CITY OF ALBUQUERQUE

July 25, 2018

**RE: Tract J-1-B of the Vista Del Norte Subdivision
Drainage & Erosion Problems (E16D022)**

ENGINEER'S SEAL	RANCHO MIRAGE • VISTA DEL NORTE	DRAWN BY BDC
	OVERALL GRADING AND DRAINAGE PLAN	DATE 06/04/03
	TERRA WEST, LLC 8509 JEFFERSON NE ALBUQUERQUE, NEW MEXICO 87113 (505)858-3100	2116GRB2.DWG
	5A	SHEET #
RONALD R. BOHANNAN P.E. #7868		JOB # 21016

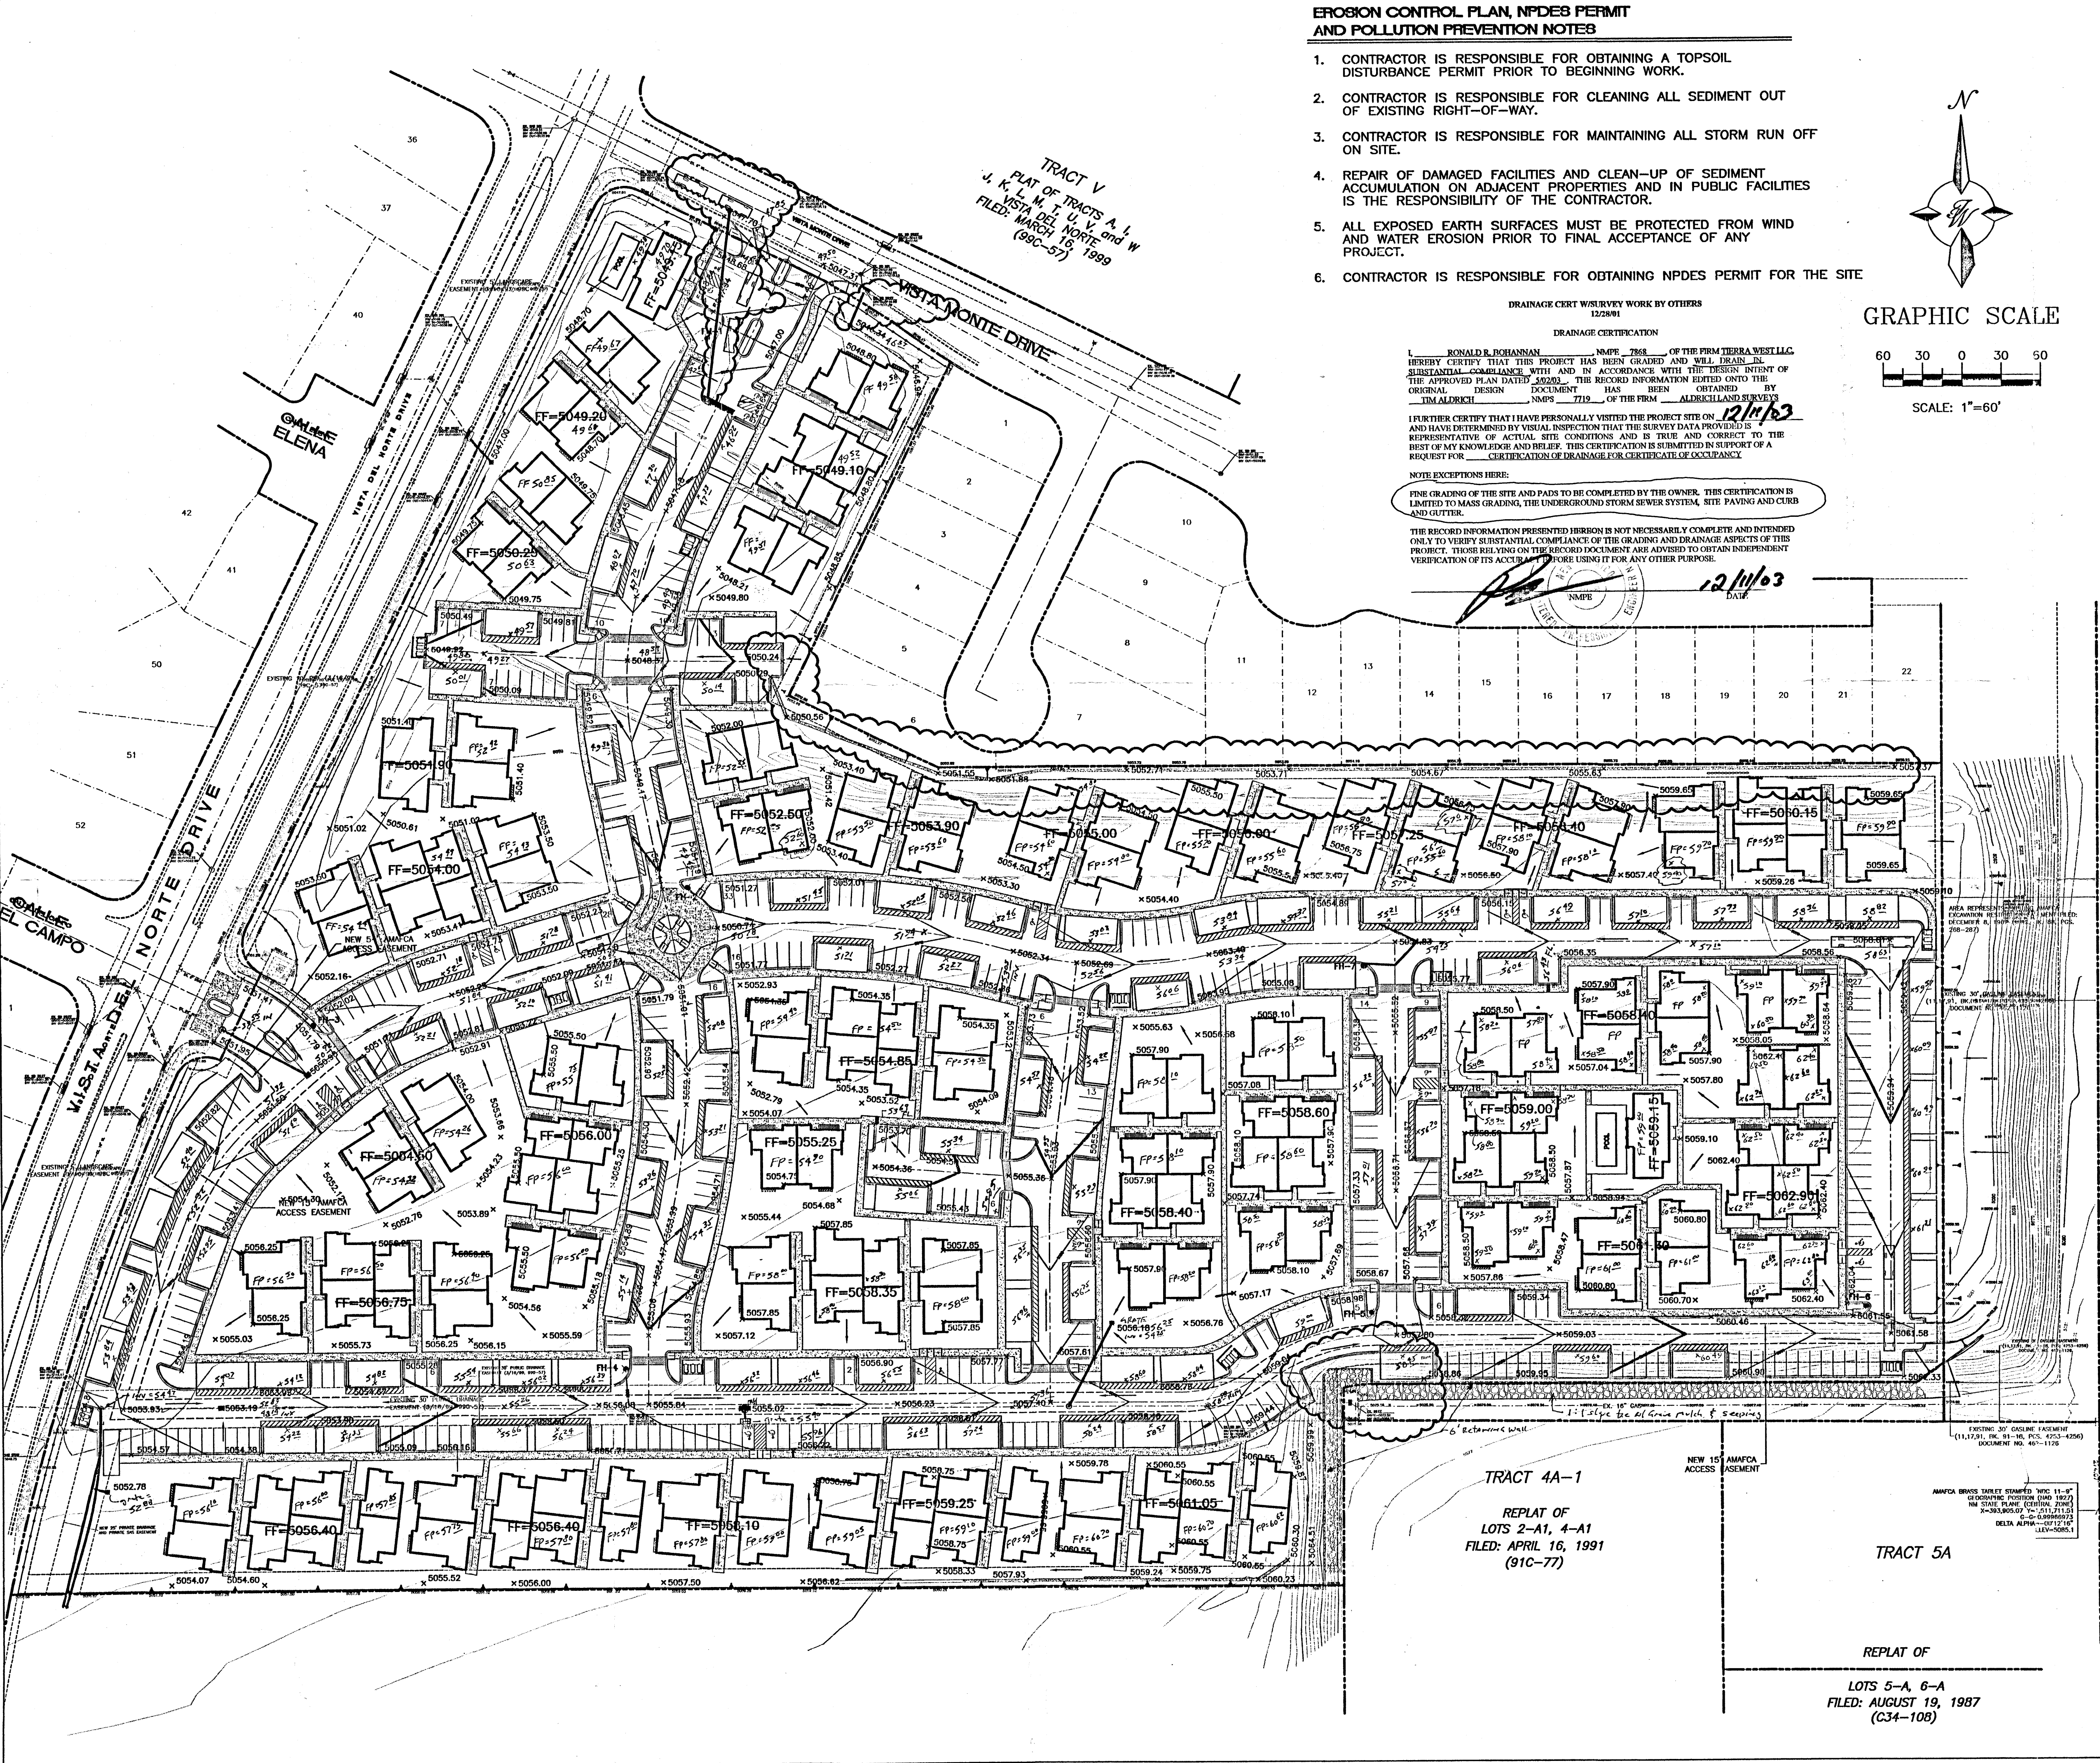
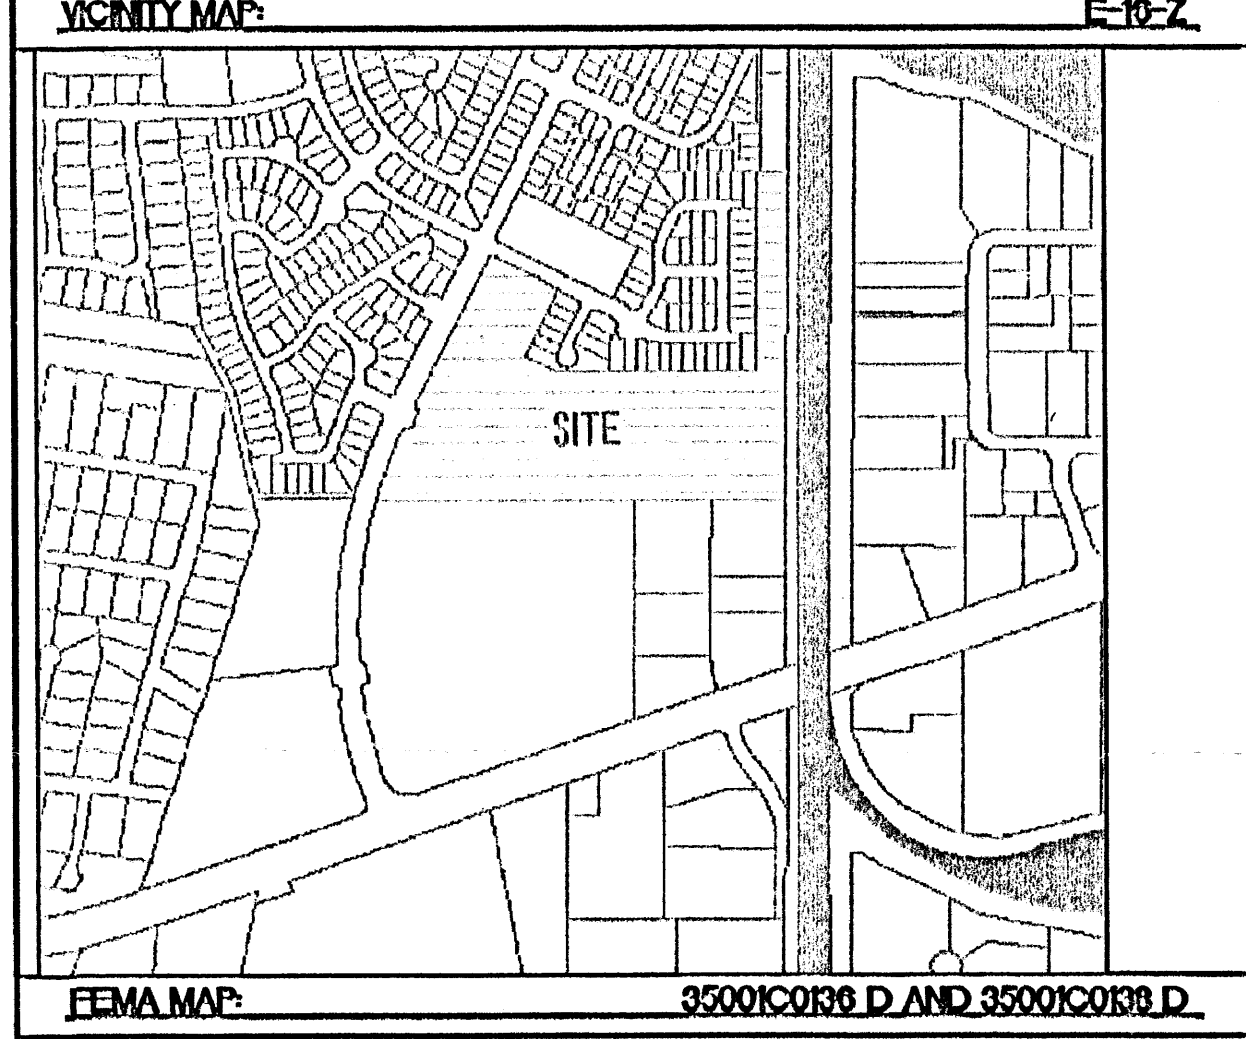
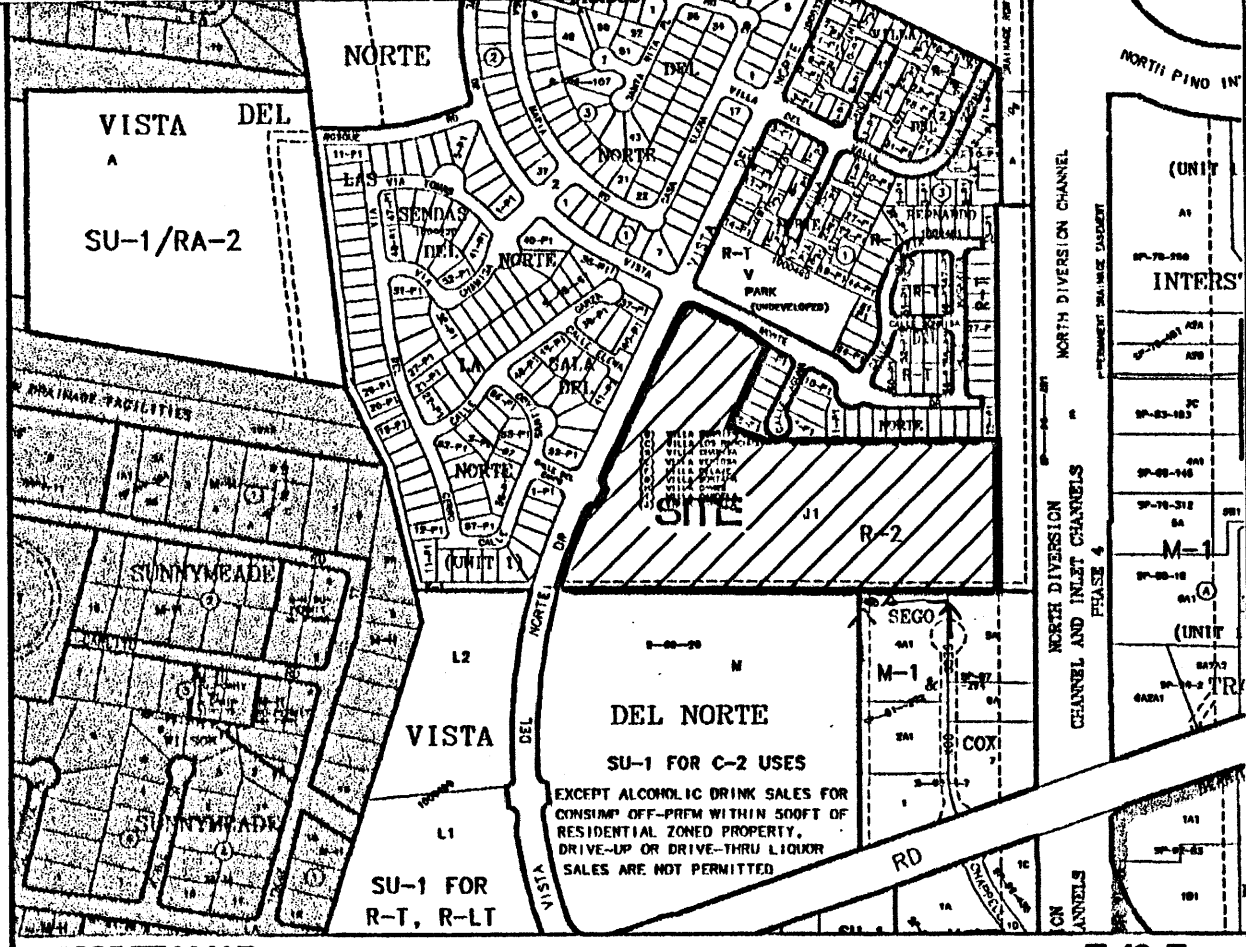
The purpose of this letter is to identify the drainage problem on the subject tract which is located between the SEGO-COX Subdivision and the Rancho Mirage Condominiums and to recommend possible engineering solutions. The problem now appears to be a 40' section of the private floodwall that leaking and causing the slope on Tract J-1-A to erode.

I inspected the City maintained inlet in the northwest corner of Tract J-1-A on June 26, 2018 and found that there was no evidence of erosion around the inlet. Instead the erosion is located on the slope next to the privately maintained floodwall south of the inlet. It is

unclear whether the drainage that caused the erosion came over the top of the floodwall or leaked under the floodwall, but the floodwall footing is hanging in the air in some locations so drainage could easily go under the wall now.

The footing of the wall does not appear to be deep enough to prevent leaks. Furthermore drainage can easily infiltrate through the dirt gap between the wall on Tract J-1-A and the asphalt paving Lot 4 of the Sego-Cox Subdivision.

One additional thing that can be done to reduce the depth of water in the northwest corner of lot 4 is increase the width of the choke point where the water exits lot 4 to the inlet. The floodwalls on Tract J-1-B constrict the flow to 10' width on the south side of the inlet.

That opening could be widened by reconstructing the floodwall and expanding the concrete apron around the inlet and thus reduce the height of flooding in the parking lot. If the width of the opening is doubled the depth of the 100 year peak flow in the parking lot may be reduced from 1.4' to 0.9' and significantly reduce the impact of leaves and debris clogging the opening. The perimeter of the grate is 18' so that is not currently the limiting factor on the capacity of the system; instead the limiting factor is the width of the opening in the floodwall south of the inlet.

Repair of both the slope and the floodwall is recommended. Maintenance of the wall and slope appears to be the responsibility of the

It is recommended that the owners of the two lots work together to rebuild the floodwall filling in the gap between the asphalt and the wall and improving the footer for the floodwall.
